# SIZEWELL C DEVELOPMENT APPLICATION

Issue Specific Hearing 7

Biodiversity and Ecology

Contribution by Tom Langton Registration ID no.: 20026399

**Plate 1.20: Indicative lighting model for SSSI crossing**

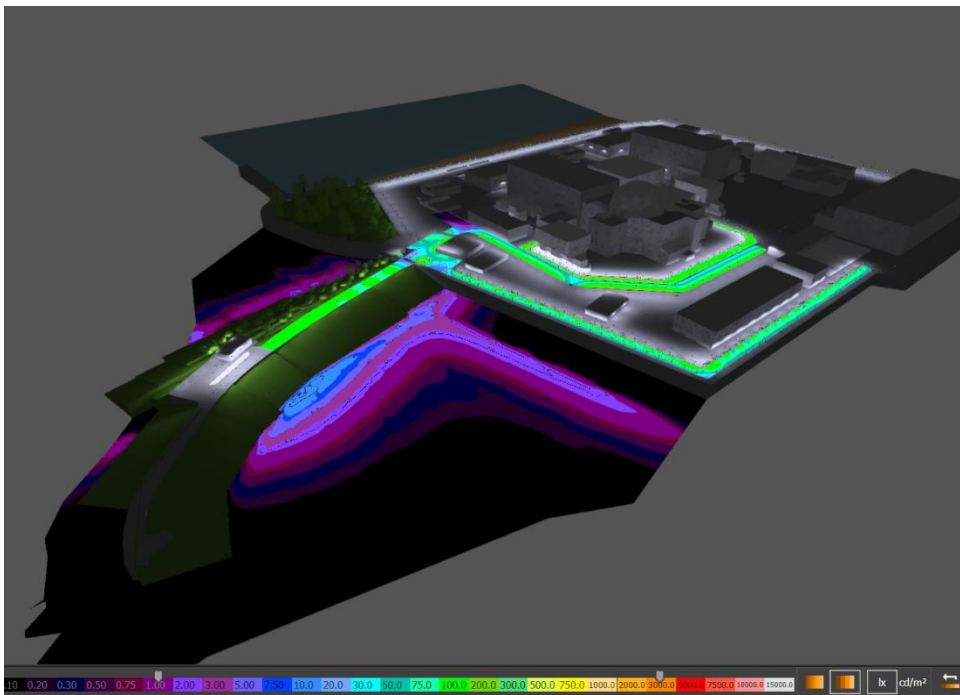
There is a chronic lack of information to be able to examine the application properly. There is inadequate information on lighting impacts and the likely effects on bats.
